SCOPING OPINION:

Proposed Little Crow Solar Park

Case Reference: EN010101

January 2019

132KV SUBSTATION LAYOUT SITE LOCATION PLAN

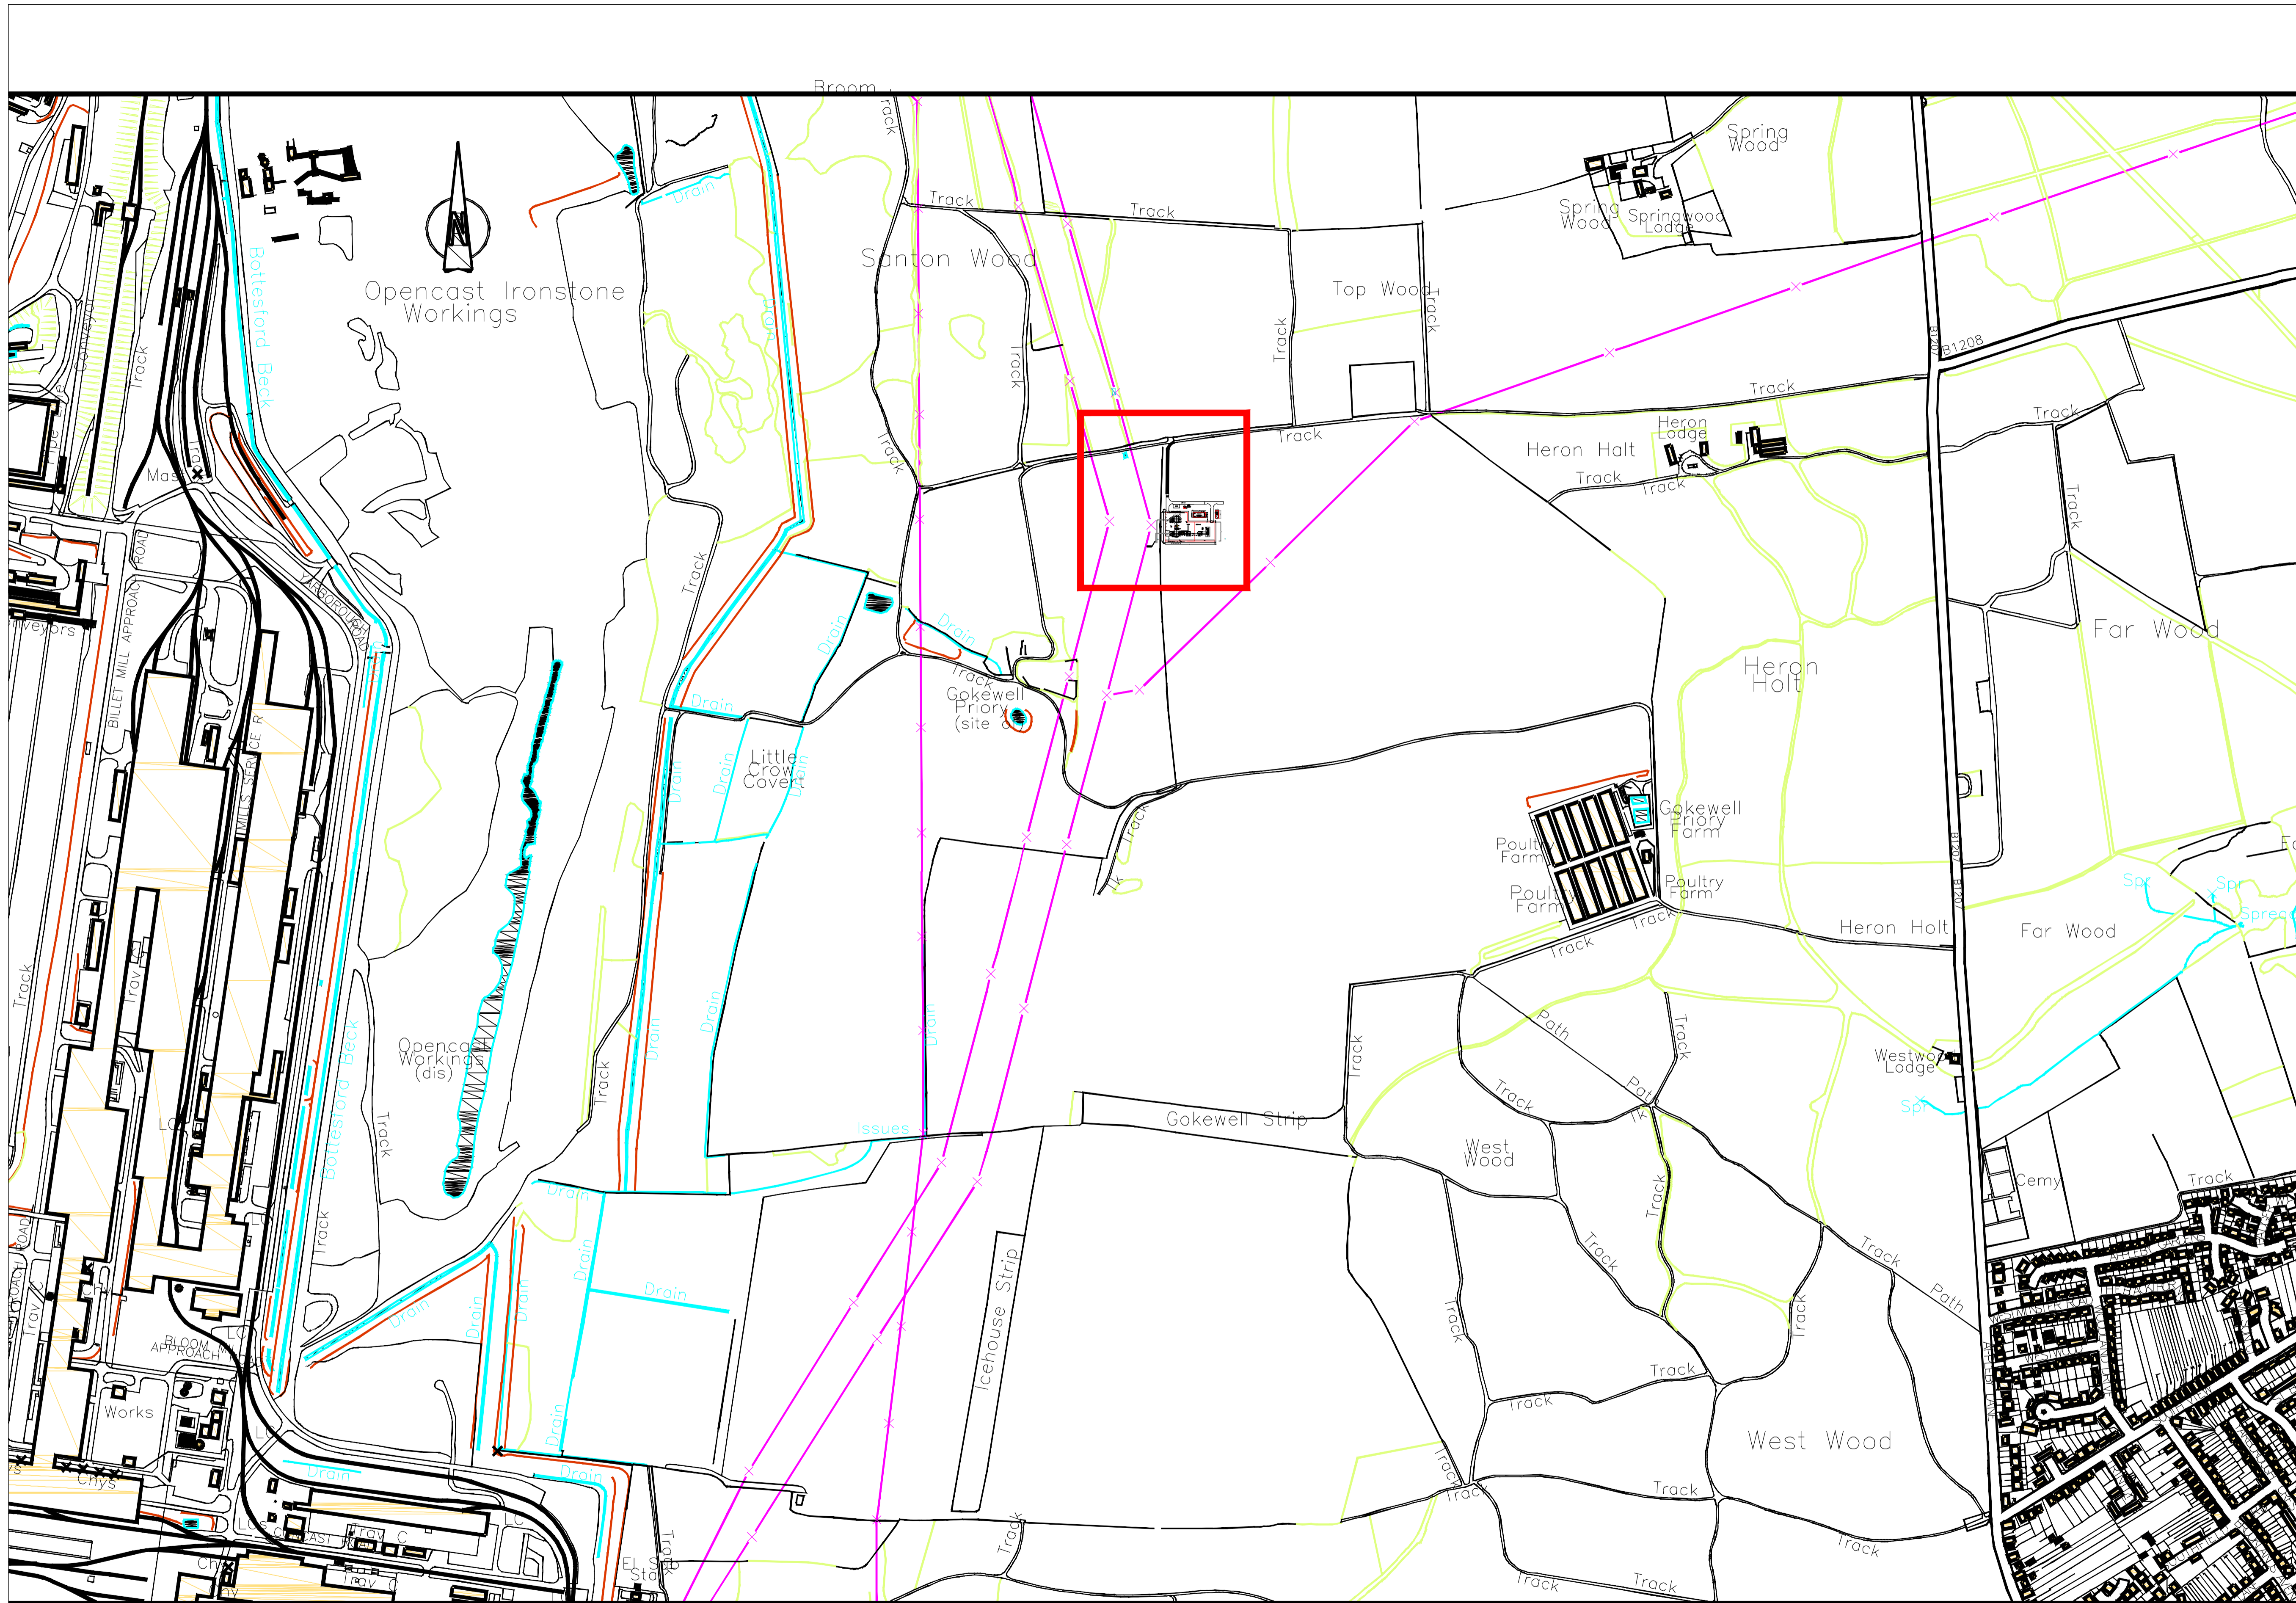
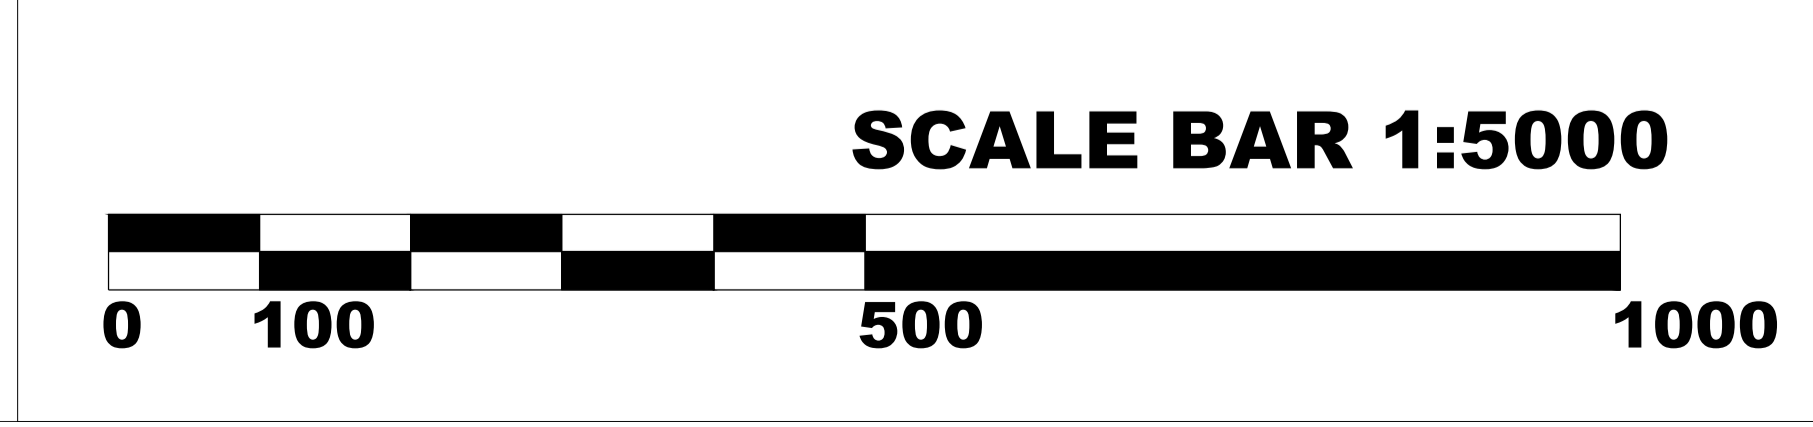
- 2.3.9 The Scoping Report omits a figure or detailed description of the proposed 132kV substation. This information should be provided in the ES.
- 2.3.10 The ES should provide a full description of any provisions and/or safeguards used to protect or maintain existing infrastructure within the site (eg the existing Anglian Water 21" main).
